DRB CASE ACTION LOG - BLUE SHEET

Project #: 1010352 Application #: 15DRB-70069
 Project Name: Parkland Hills Addn
 Agent: Community Sciences Phone #:

**CITY OF ALBUQUERQUE
PLANNING DEPARTMENT
February 4, 2015
DRB Comments**

RE: Lots 14-16, Parkland Hills

**PLAT OF
 LOTS 14-A and 15-A
 BLOCK 34
 PARKLAND HILLS ADDITION**

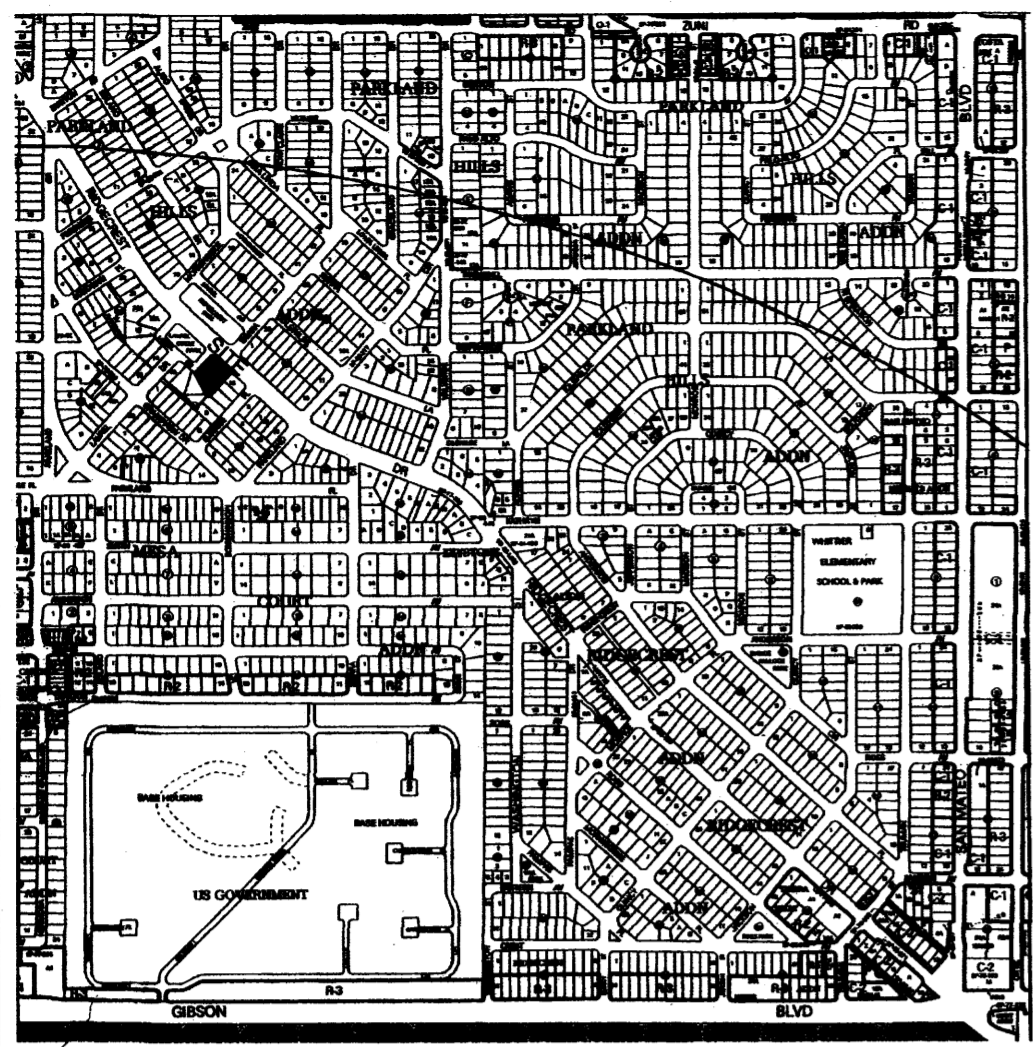
A copy of the 1963 mortgage is needed for portion of Lot 16.
A complete line table needs to be provided.
